CITY OF ALBUQUERQUE

October 21, 2014

**Re: Resort Lifestyle Communities
Conceptual Grading and Drainage Plan
No Engineer's Date (D18D054C)**

Based upon the information provided in your submittal received 10-16-14, the above referenced plan is not approved for Site Development Plan action by DRB nor Building Permit. Address the following comments:

CONCEPTUAL GRADING & DRAINAGE PLAN

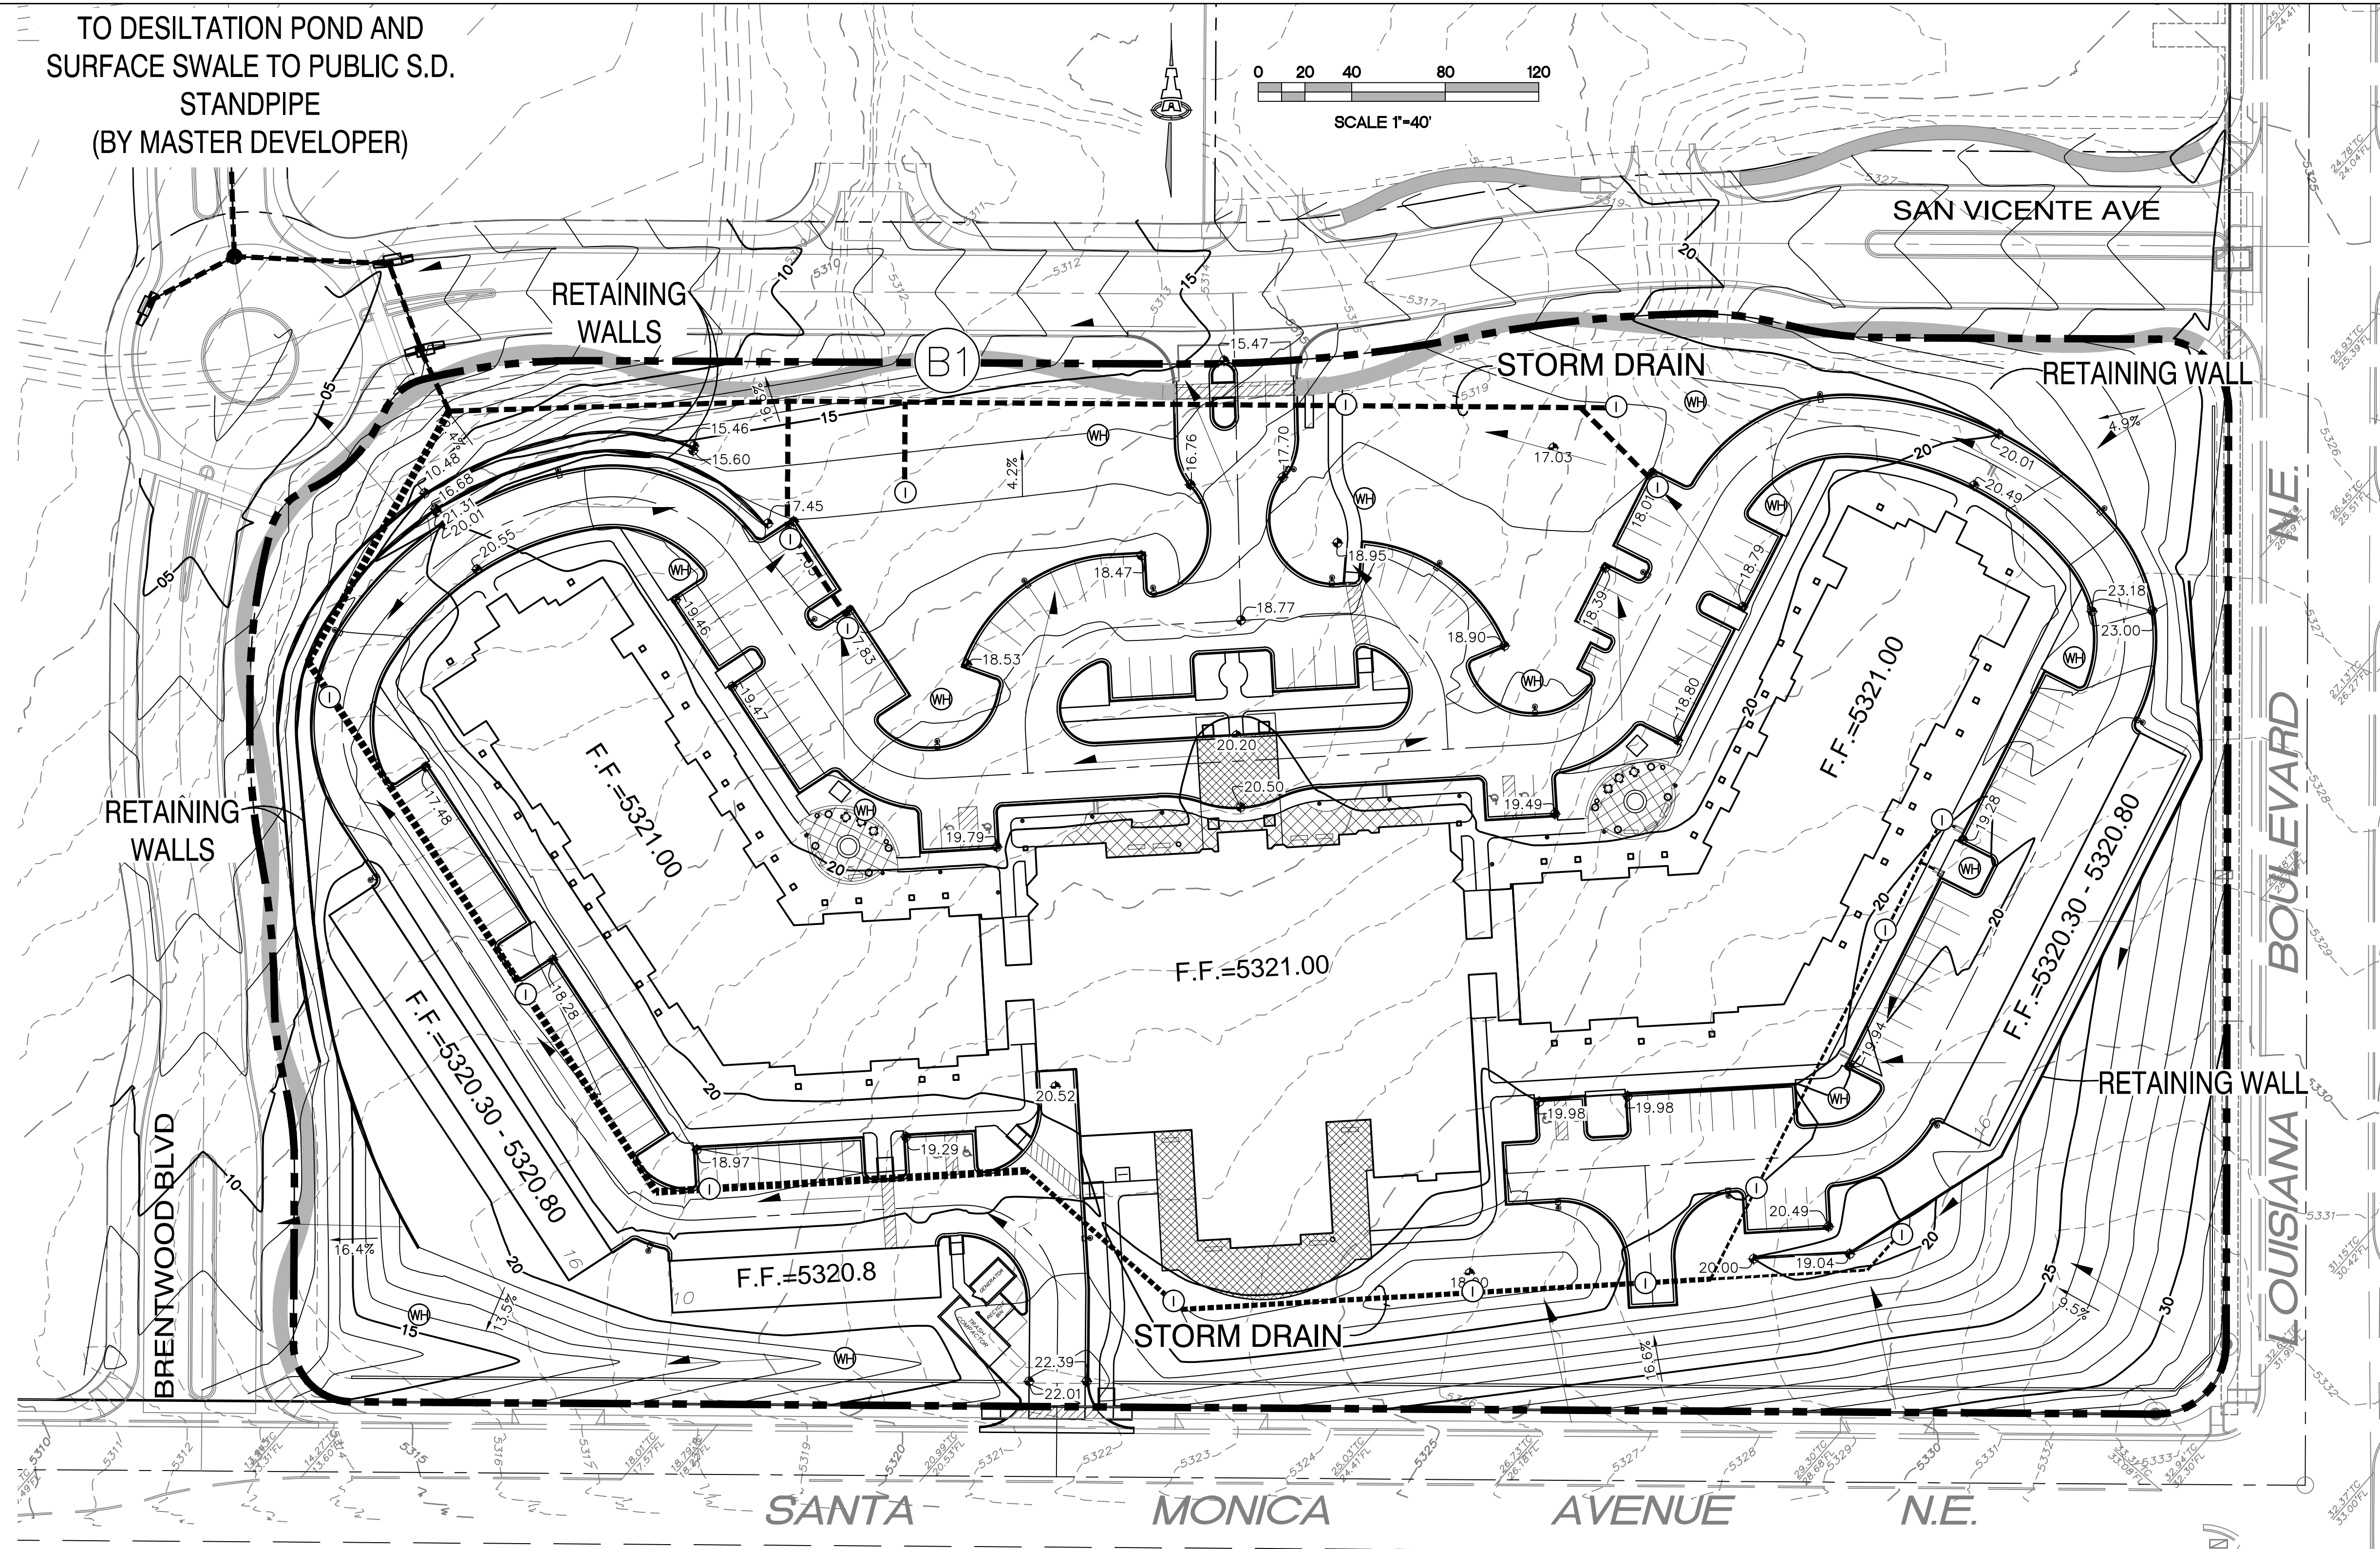
1. The Master Drainage Report for Tracts 3A, 3B, 4A, and 4B has been approved. The report specifies the drainage development parameters for the proposed Tract 4B (Resort Lifestyle Communities' tract). Show how the site is meeting those requirements. The allowable discharge for this site is 30.9 cfs not 35 cfs. Revise the calculations and narrative accordingly.
2. A discussion of the First Flush has been added to the plans. The volume required and the volume provided should be included also. Do you have sufficient room for the First Flush with the current site plan?

Per the City Drainage ordinance, the 90th Percentile Storm Event, which is 44 inches, is to be managed. Reduce 0.44 inch by the 0.1 inch for the initial impervious abstraction in Table A-6 of Section 22 of the DPM. Multiply the remaining 0.34 inch by your impervious area. This is the portion to retain.

3. Show how this site will be connecting to the proposed 18 inch storm drain that will be done by separate work order.
